Application No: FG/149/20/PD  
Site Address: 11 Sea Lane Ferring BN12 5DR  
Description of works: Prior notification under Schedule 2, Part 3, Class O of the Town & Country (General Permitted Development (England) Order (as amended) for the change of use of the existing first floor of the building from office (Class B1(a)) to 4 No. residential dwellings (Use Class C3) .

Thank you for your internet representation made on 25th November 2020 which has been recorded as an objection with the comments as follows:

GROUND FLOOR PLAN 1:100 @ A3 / 1:50 @ A1

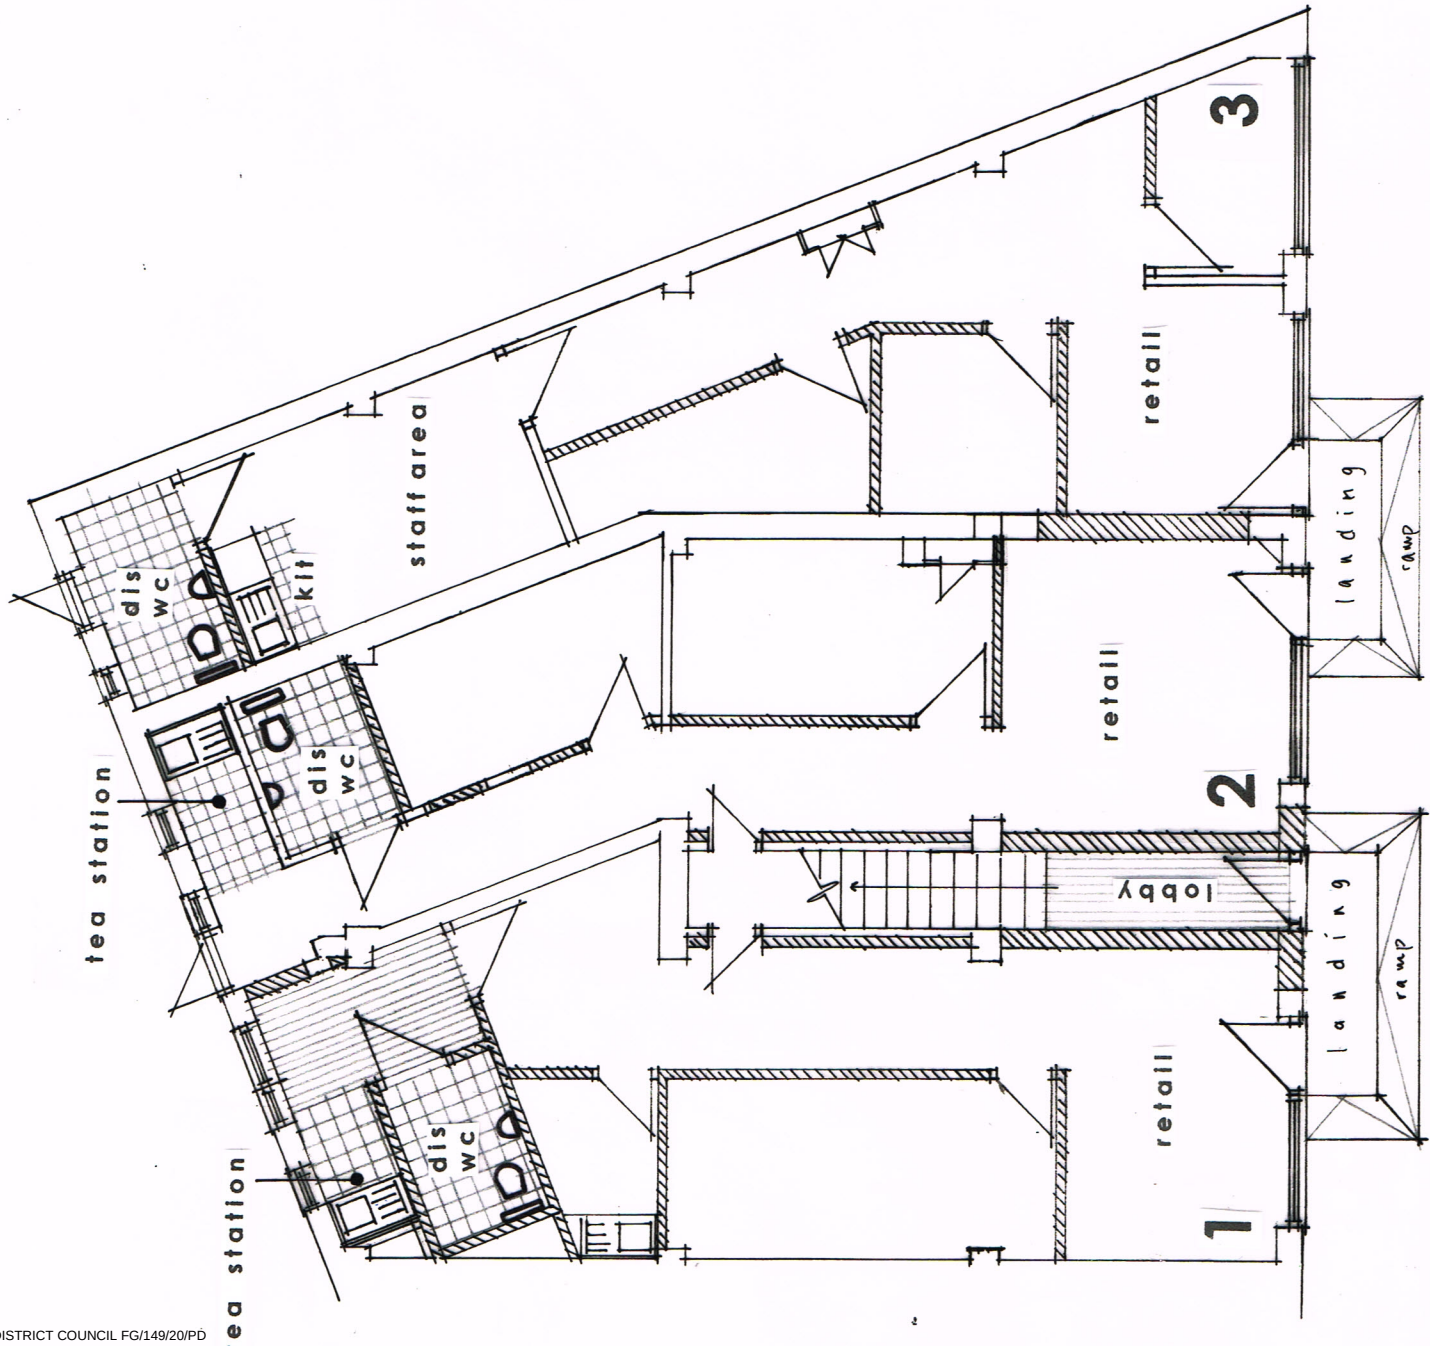
We have no objection to the conversion of the ground floor, from offices to three retail units, but the parking provision proposed in FG/149/20 is not enough for the combination of the proposed three shops and four dwellings. The shops' staff, deliveries and customers would need all the six spaces referred to in the planning statement (in fact, the photograph in the planning statement shows room for only five). Other parking would have to be on-street, in a village centre which is already full of parked cars, making shopping and driving-through more and more difficult.

1st FLOOR PLAN

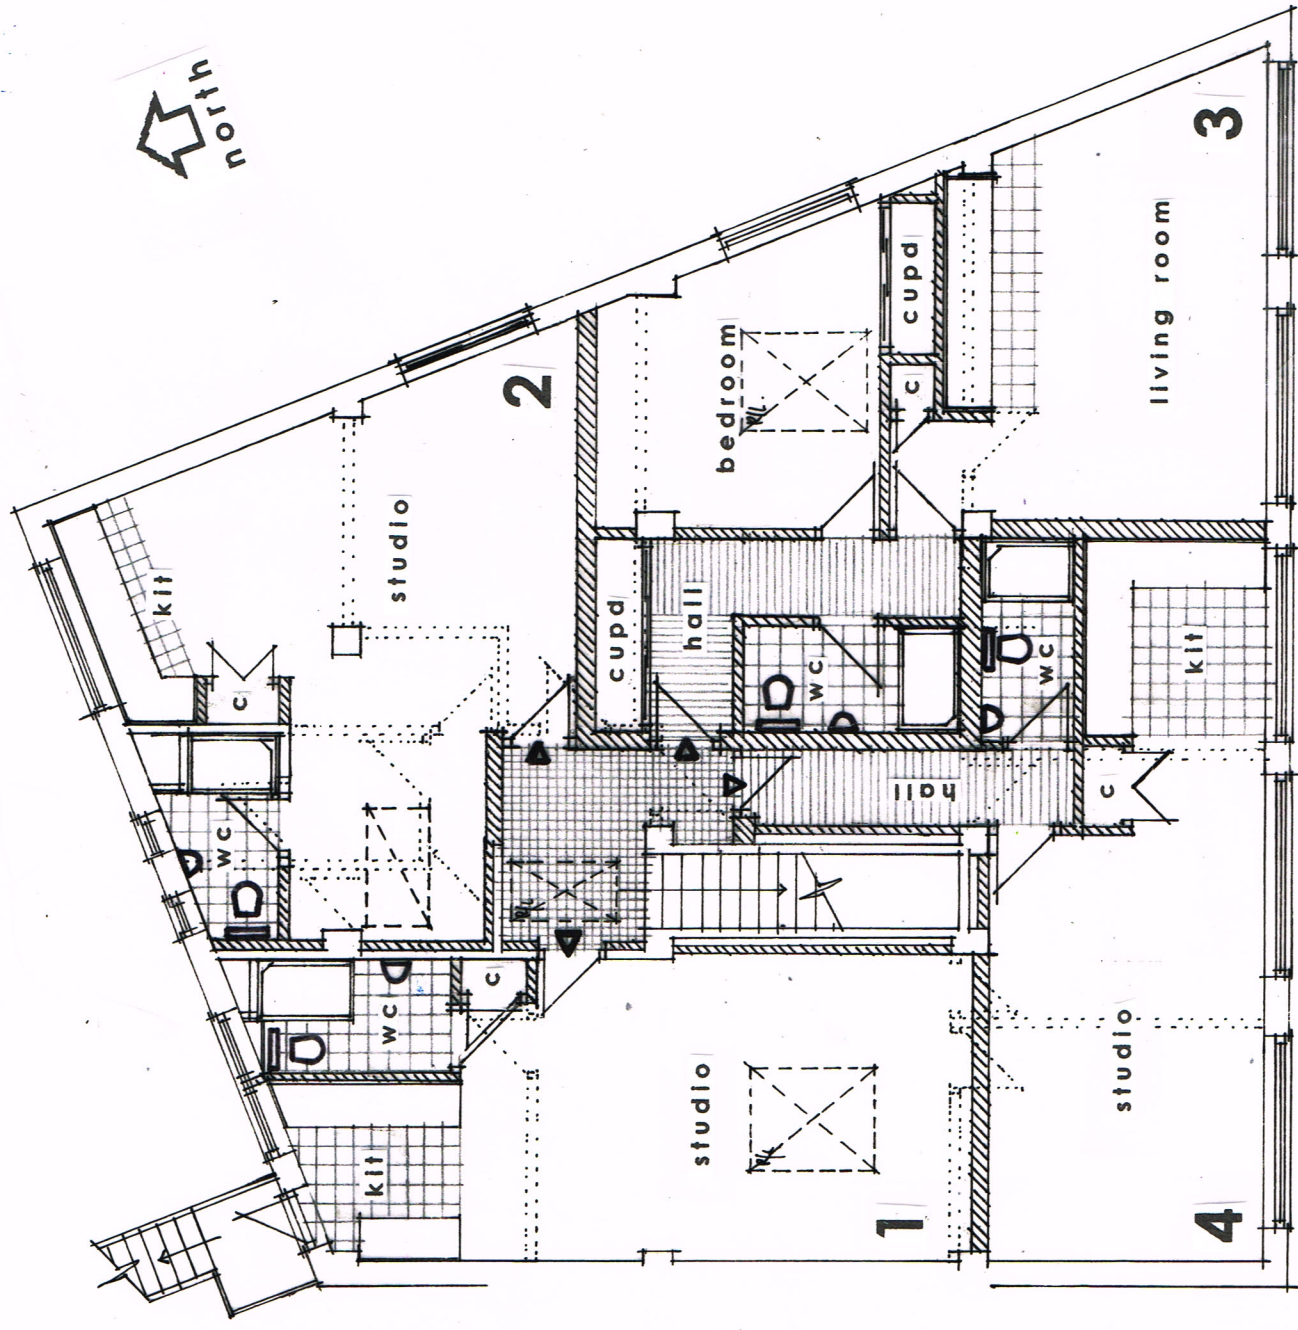
The accommodation may meet national minimum space standards but the three 'bed-sits' and one 1-bedroom flat are far smaller than any other dwellings in Ferring and are not appropriate to an established residential area.

Four dwellings is overdevelopment and should be refused - Ed Miller (Secretary, Ferring Conservation Group)
